DESIGN STATEMENT BY THE CONSULTANT

PROJECT: **Sutherland Hospital**

LANDSCAPE ARCHITECTS: **Arcadia Landscape Architecture P/L**

Date: 31st July 2015

01.06 LANDSCAPE DRAWINGS

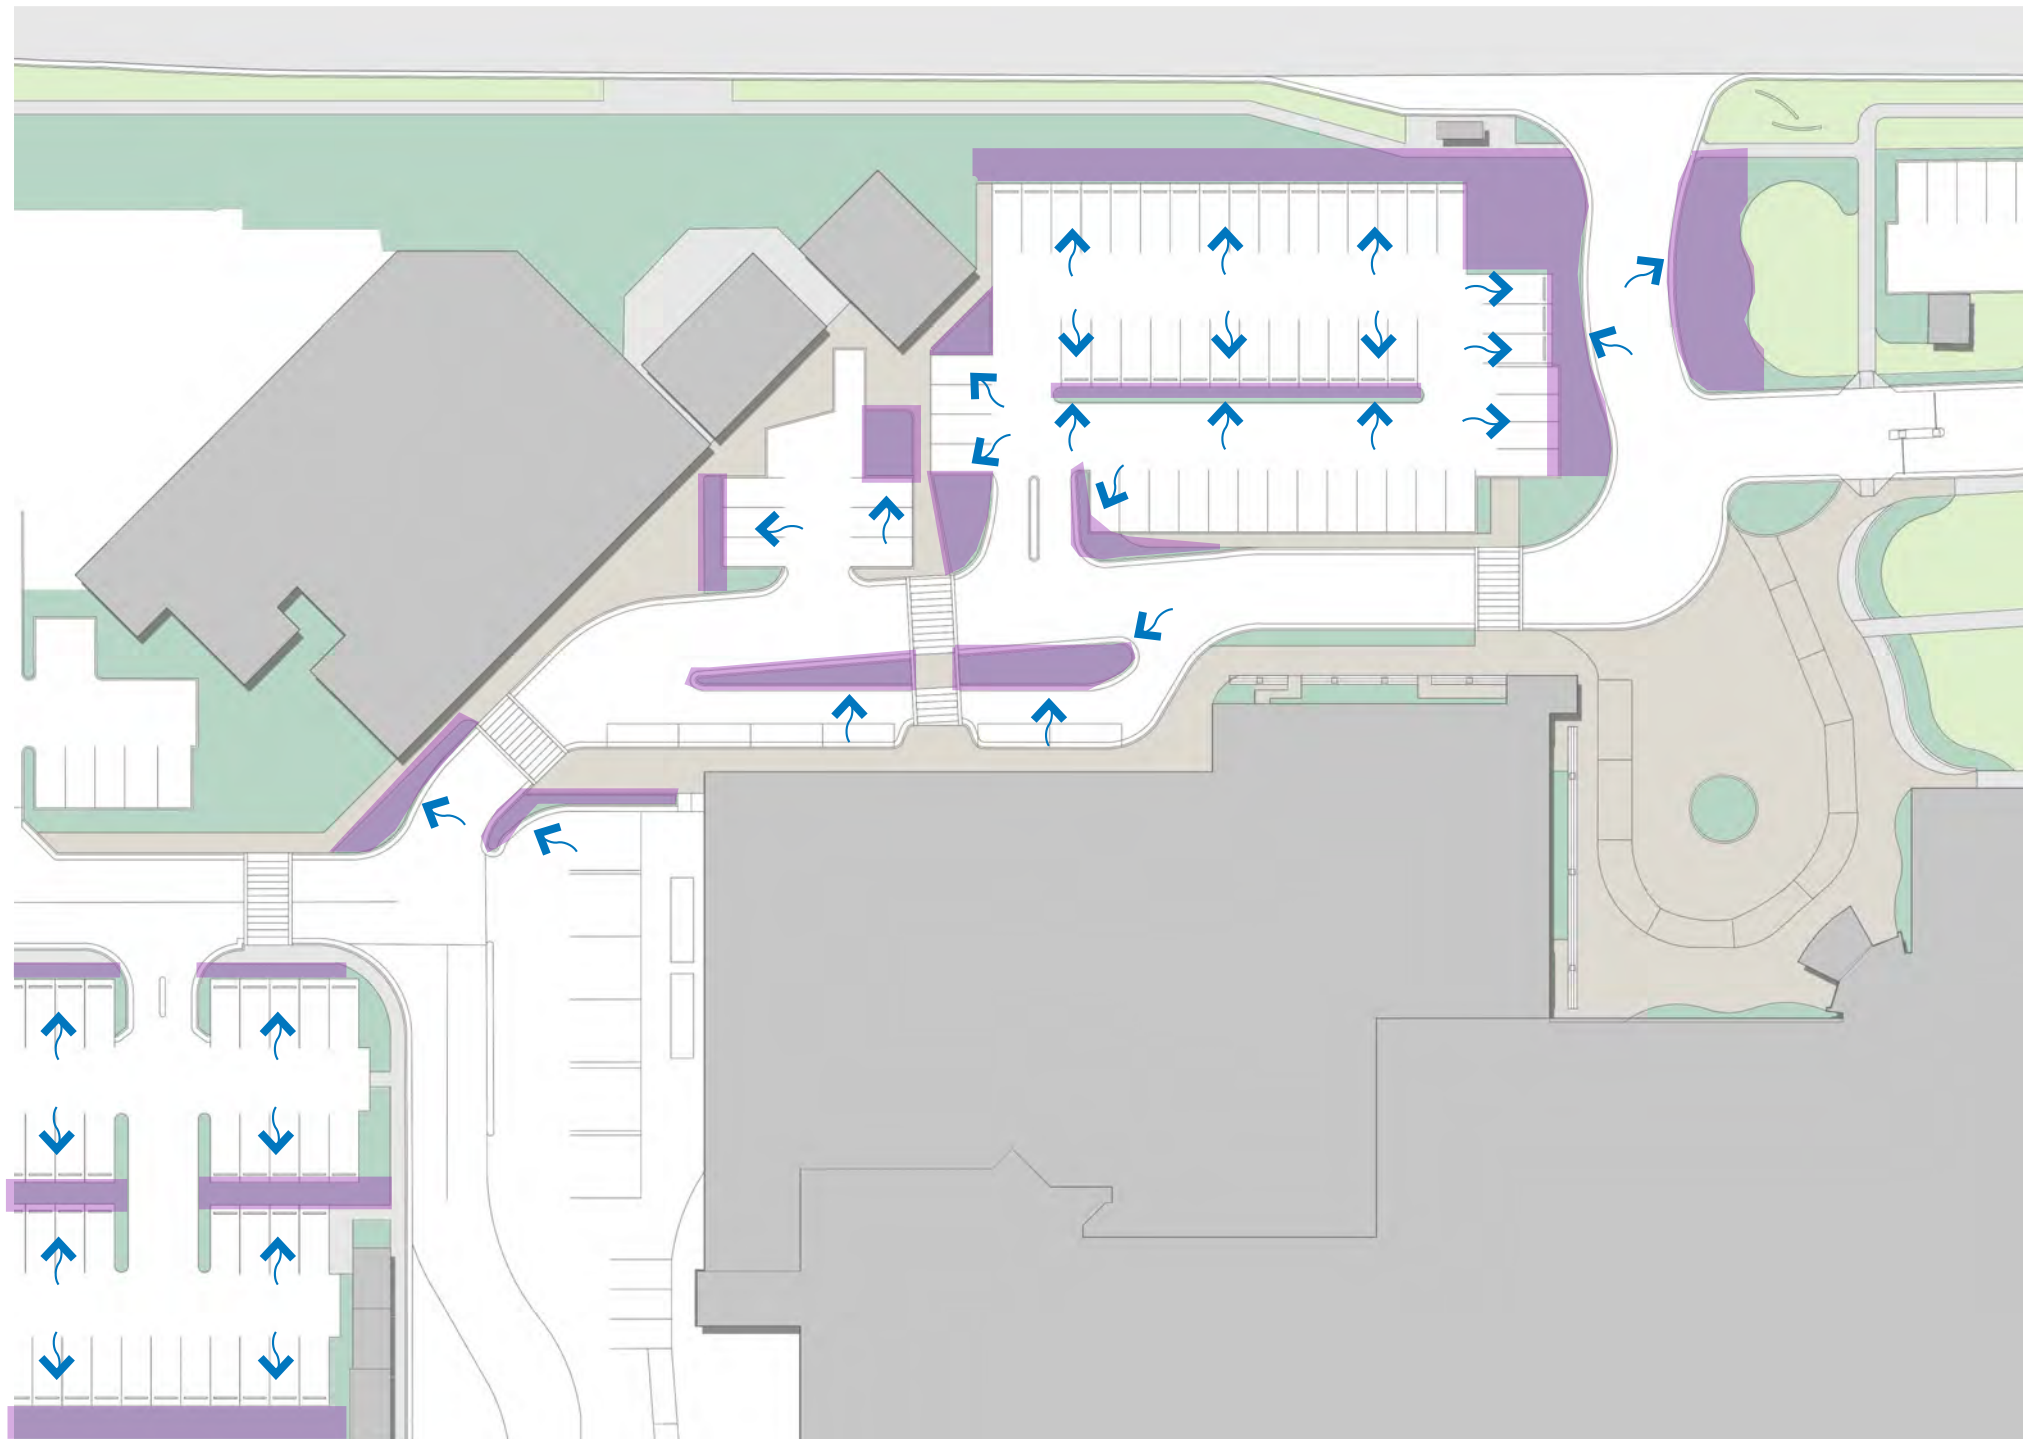
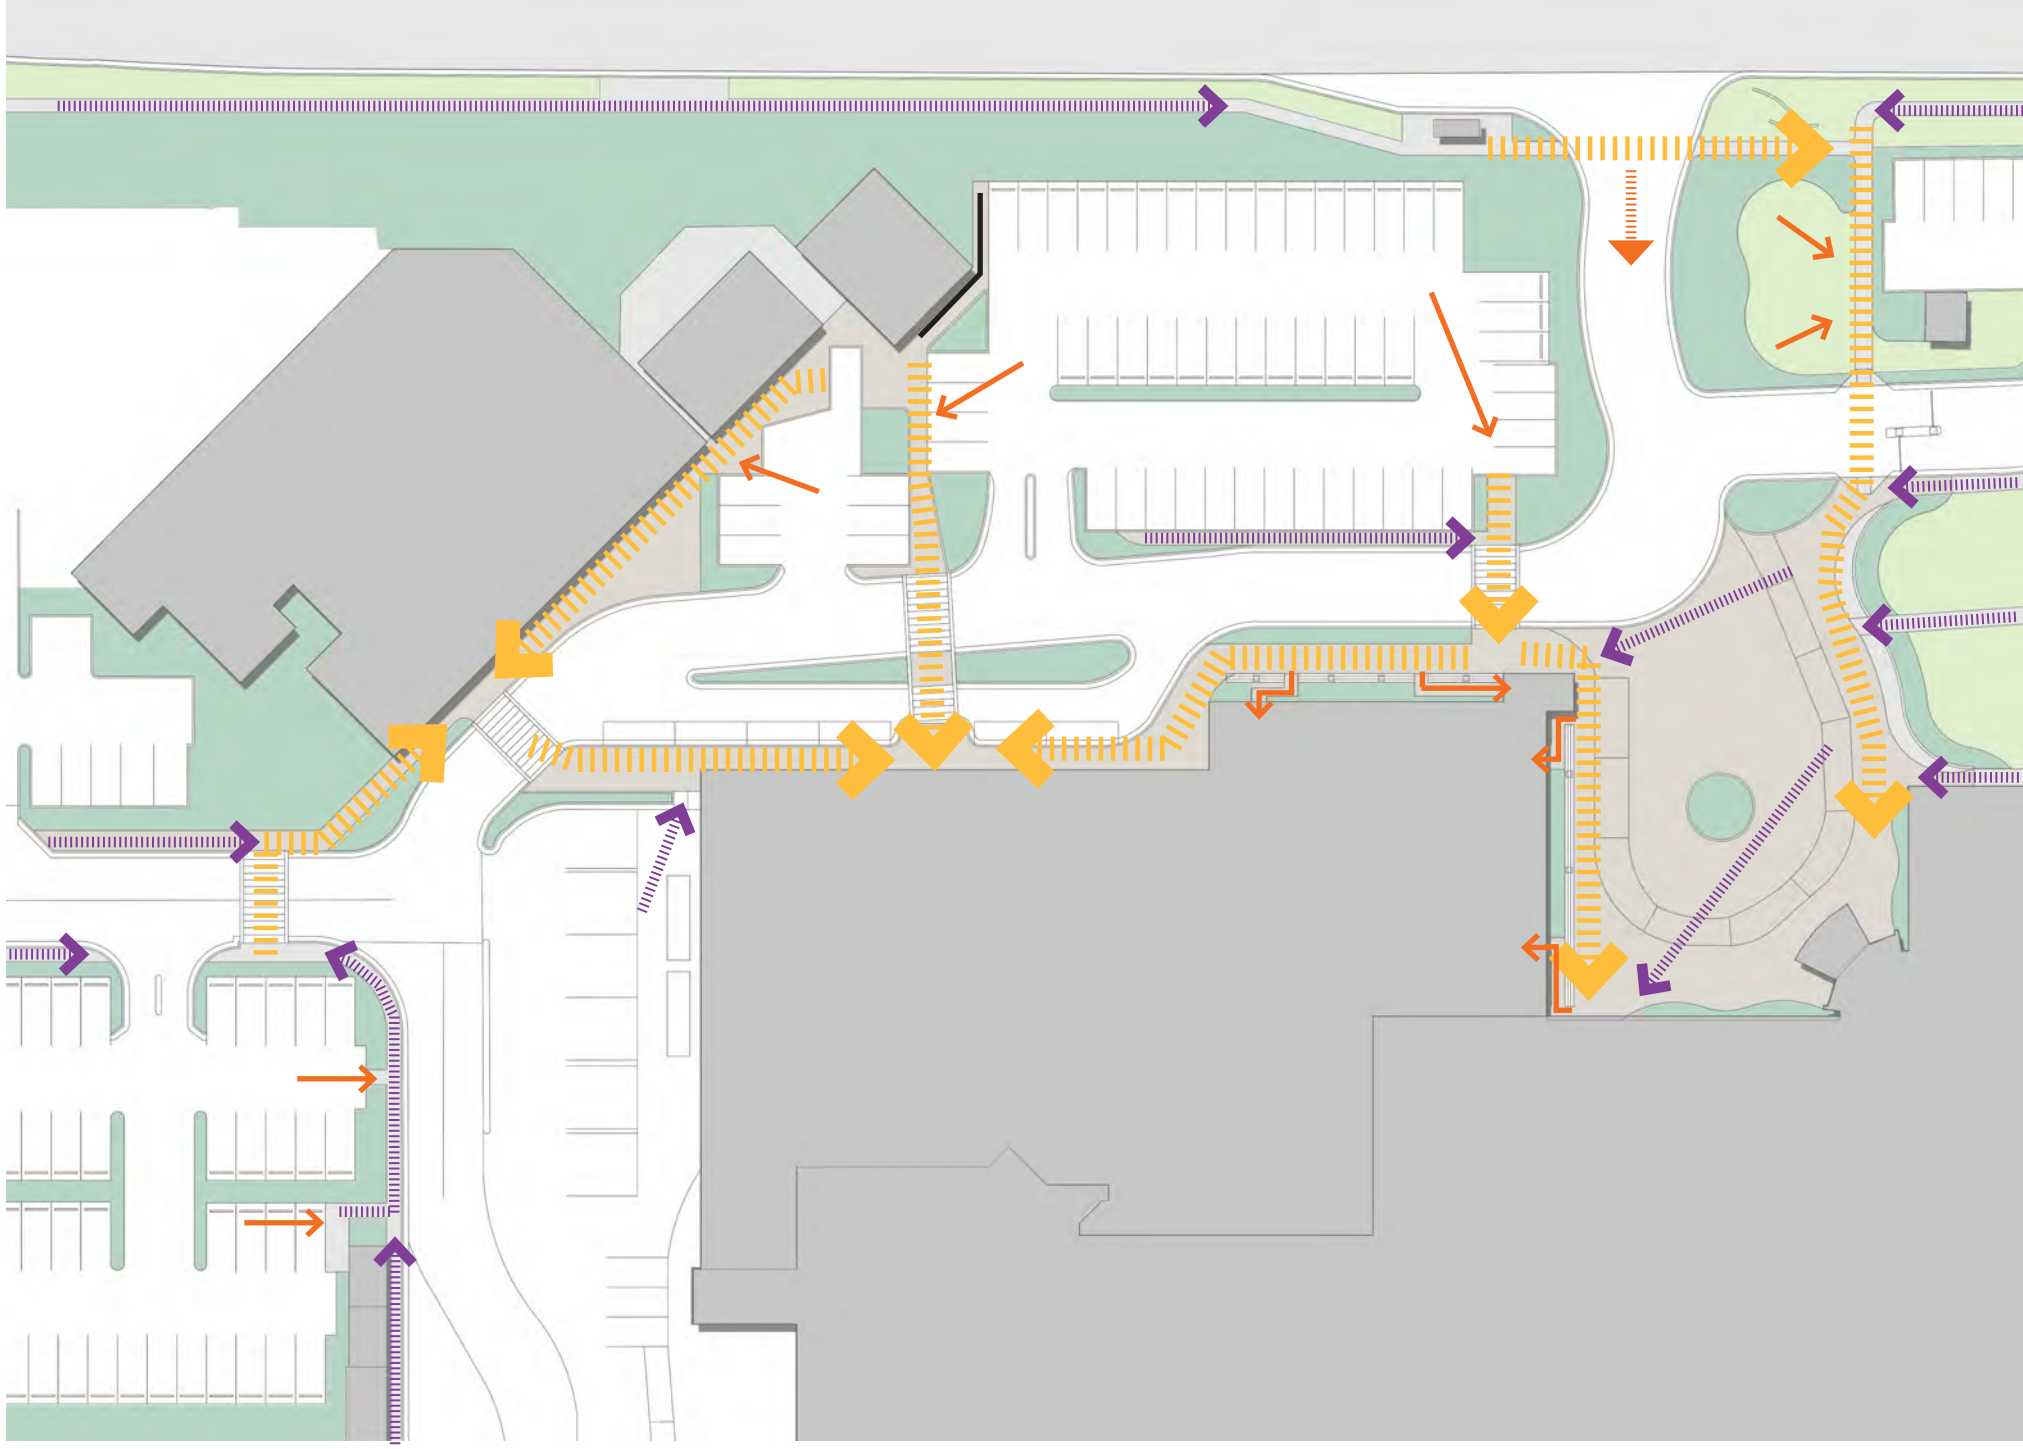
In response to Council's request for the inclusion of 100% indigenous tree planting and 50% indigenous shrub and grass planting, we can confirm that we have sufficiently met the condition of 50% indigenous shrub and grass species.

Please note Council's request for 100% indigenous tree species has not been completely fulfilled. The indigenous tree species list provided by Council was not very extensive and as a result was not suitable for all areas of the proposed design.

Following careful review of the Indigenous tree list, we were unable to identify an appropriate tree species for the hospital building entry and shareway. It is in our opinion that a *Corymbia maculata* (Spotted Gum) would be a suitable tree species for the areas nominated above.

As per the Arborist Report, there are numerous locations on site where *Corymbia maculata*'s currently exist, including along the hospital driveway entrance. In order to stay consistent with our site narrative in enhancing/extending the local landscape character, we advise that this species would be most appropriate. There are currently three beautiful and healthy *Corymbia maculata* specimens located to the hospital driveway entry and we believe continuing this tree character into the site as part of the entry experience is integral to the overall design.

The *Corymbia maculata* tree species would be the only plant we have selected that diverts from the 100% indigenous tree planting request. While this tree species is not indigenous to the site, it is a commonly used Australian native tree found extensively in the wider community and along the Sydney coastline.
